Addendum No. 1

RE: Contract # C204450

BRIDGE #28 ON SR-1007 OVER NEUSE RIVER AND BRIDGE #240 ON SR-2509 OVER NEUSE RIVER.

The following revisions have been made to the Structures plans.

SHEET NO. S2-11  
TOTAL SHEETS 73

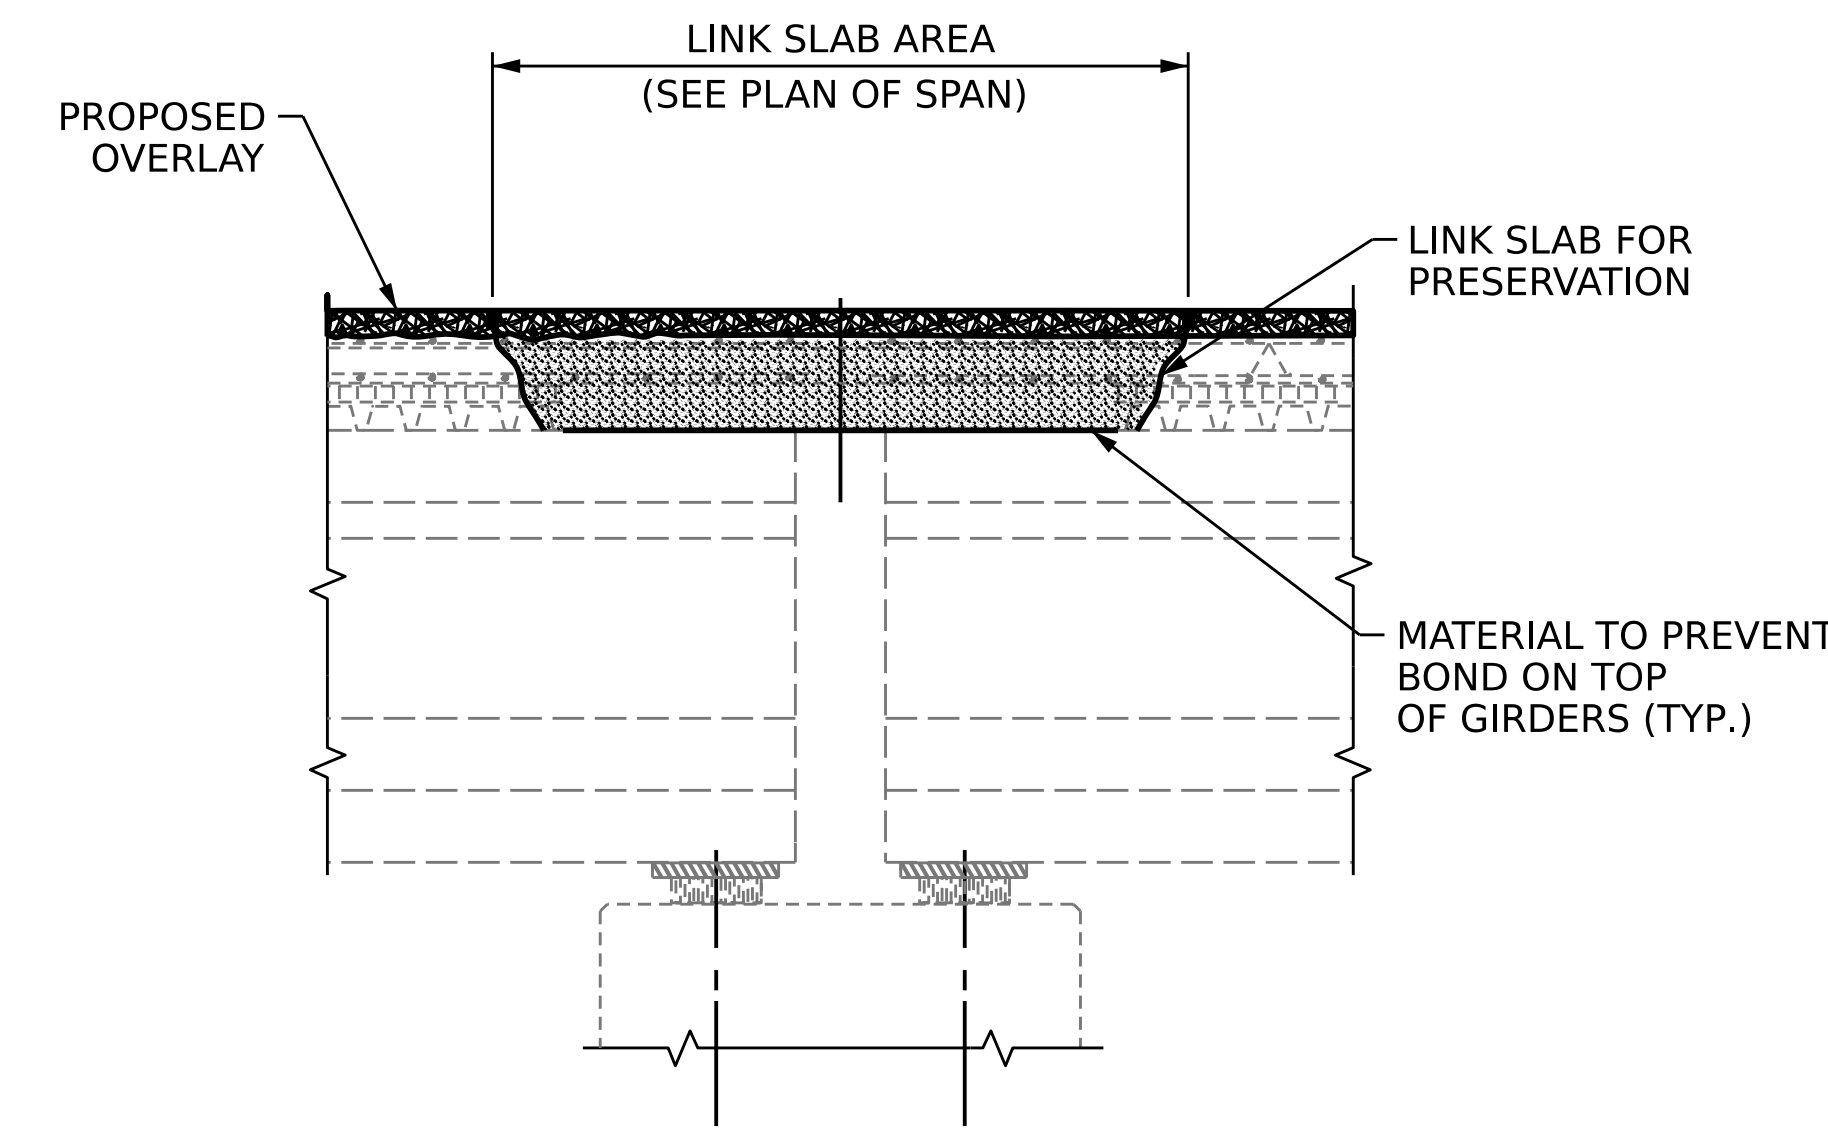
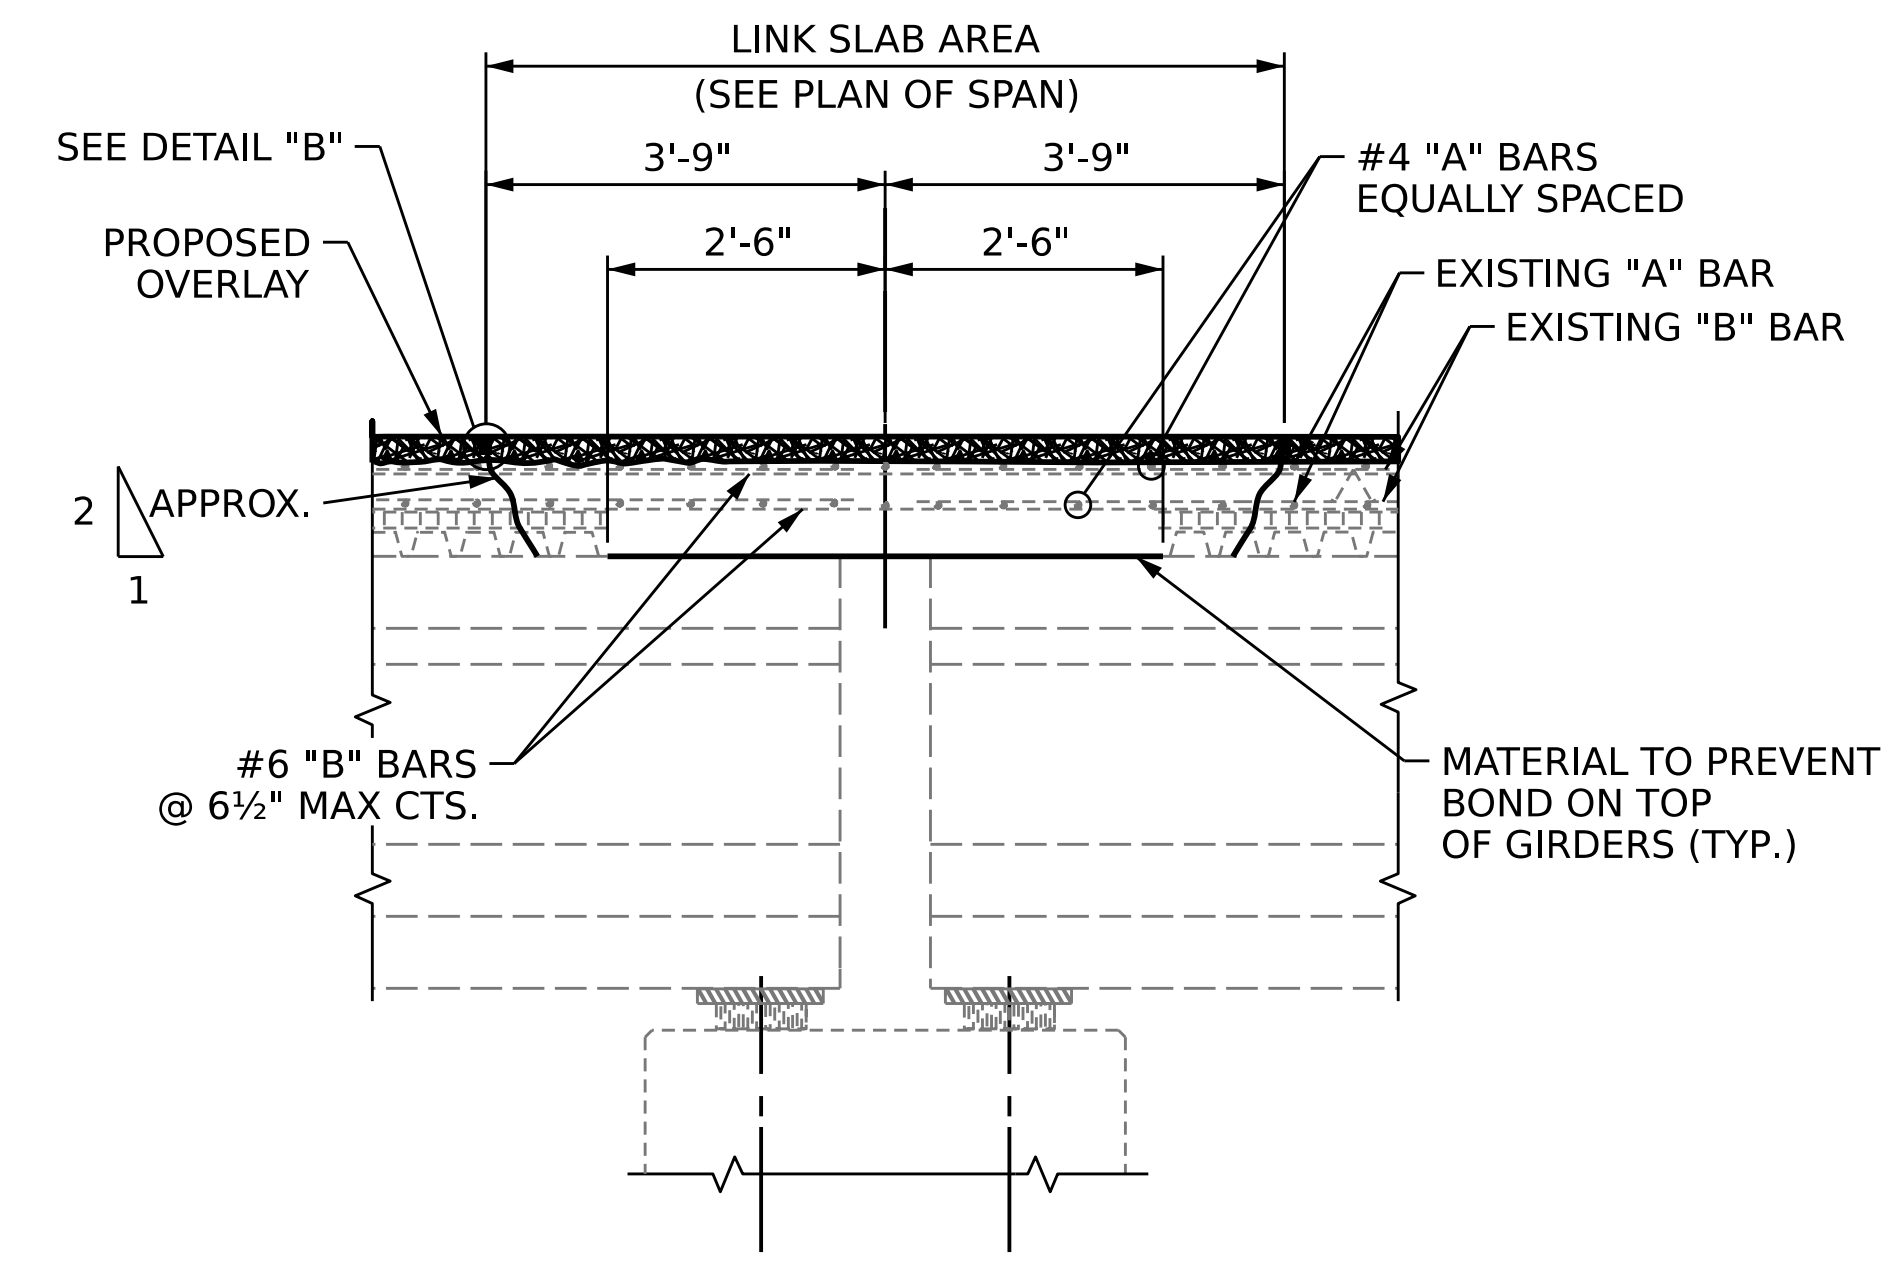
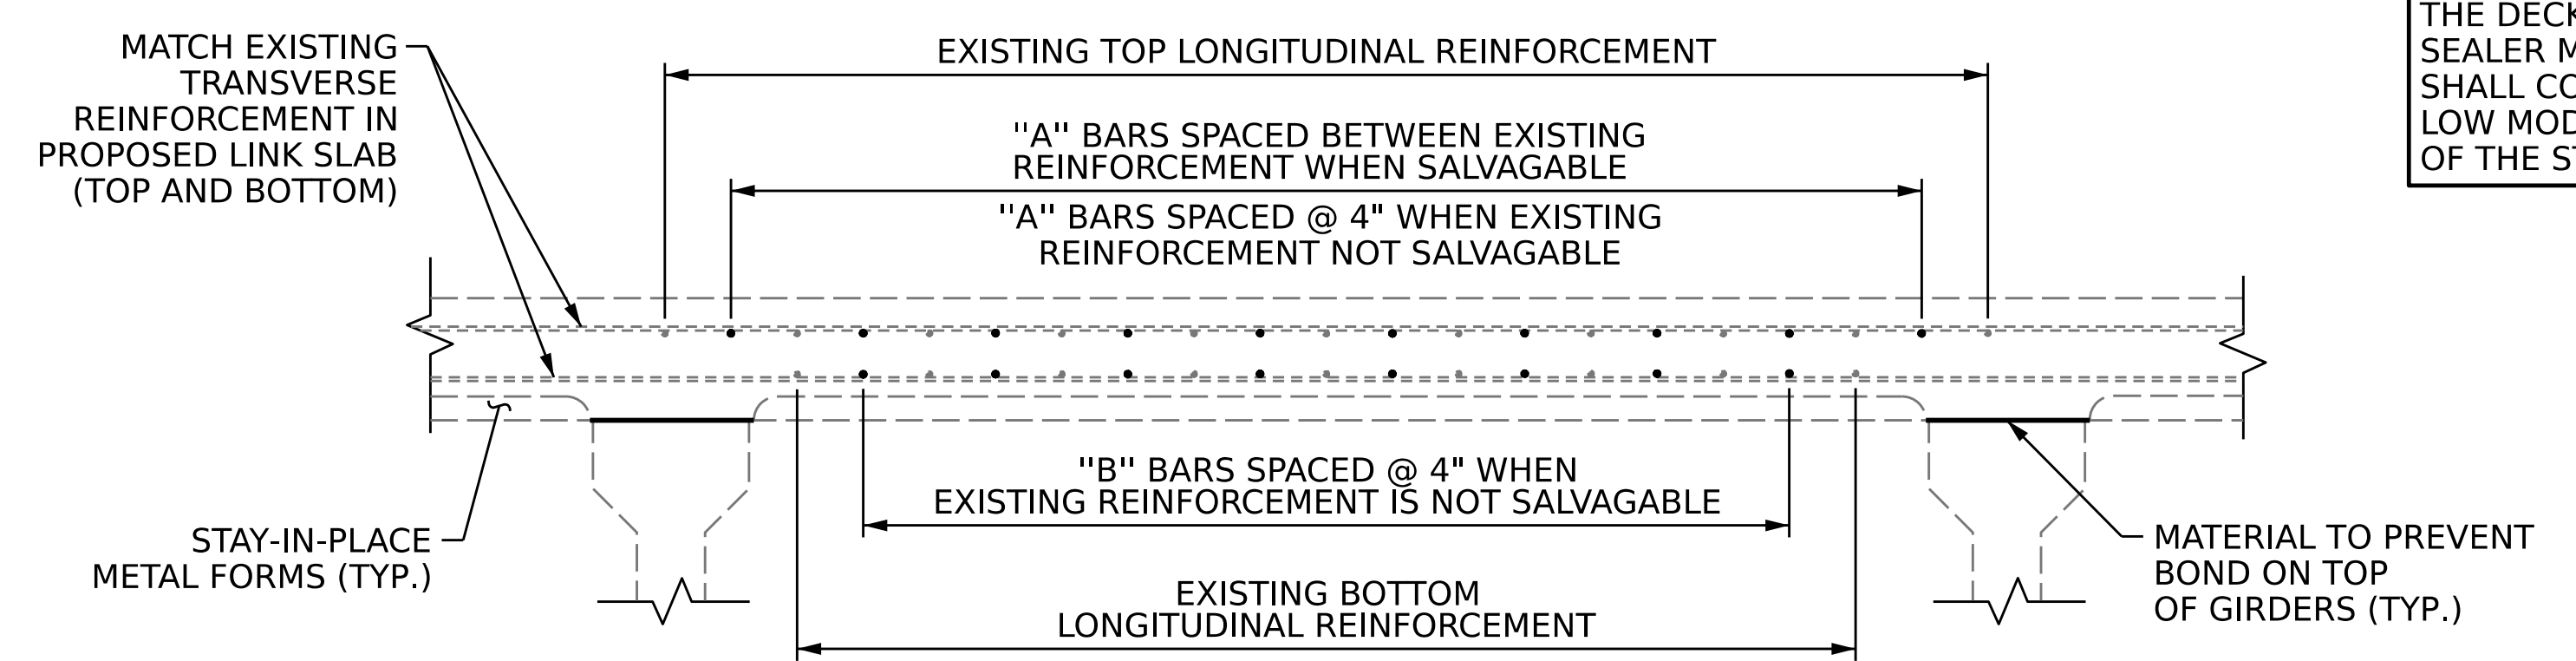
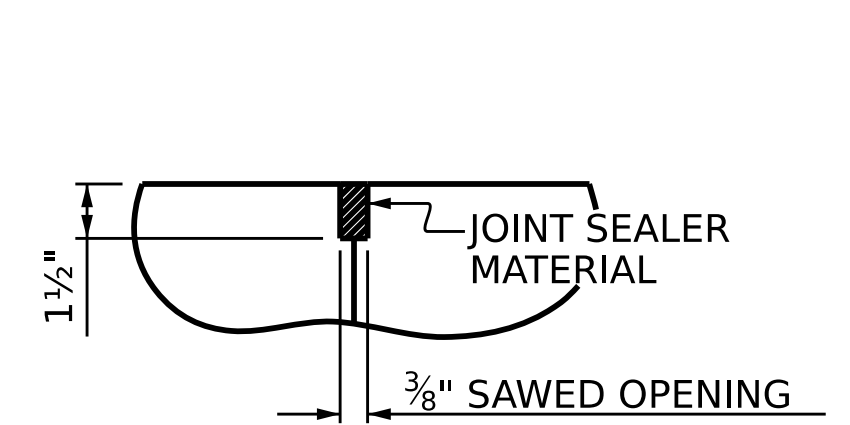
Sheet No.	Revision
S-2	Quantities for "Incidental Milling" and "Link Slab for Preservation" updated.
S2-11	"Notes" were updated.
